**WEST SUSSEX COUNTY COUNCIL
STRATEGIC PLANNING CONSULTATION**

SUBJECT: AL/130/16/OUT - Outline Application with some matters reserved for 1No. 5 person 3 bedroom bungalow, with 8No. parking spaces, bin and cycle store.

Land adjacent of, 14 St Johns Close, Westergate, Aldingbourne, PO20 3TH

location plan &
proposed site plan

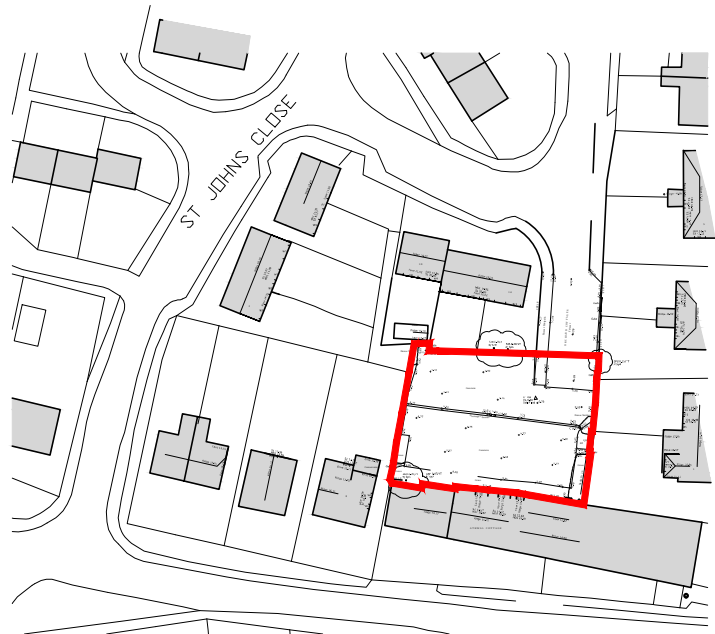
From an inspection of the plans the LHA are satisfied that the site can facilitate turning for cars and access for Fire and Refuse Vehicles is achievable.

There are a limited range of local amenities within walking distance. I would advise that secure and covered bicycle storage is included and kept in perpetuity.

No part of the development shall be first occupied until covered and secure cycle parking spaces have been provided in accordance with plans and details submitted to and approved by the Local Planning Authority.

No part of the development shall be first occupied until the vehicle parking and turning spaces have been constructed in accordance with the approved plan. These spaces shall thereafter be retained for their designated use.
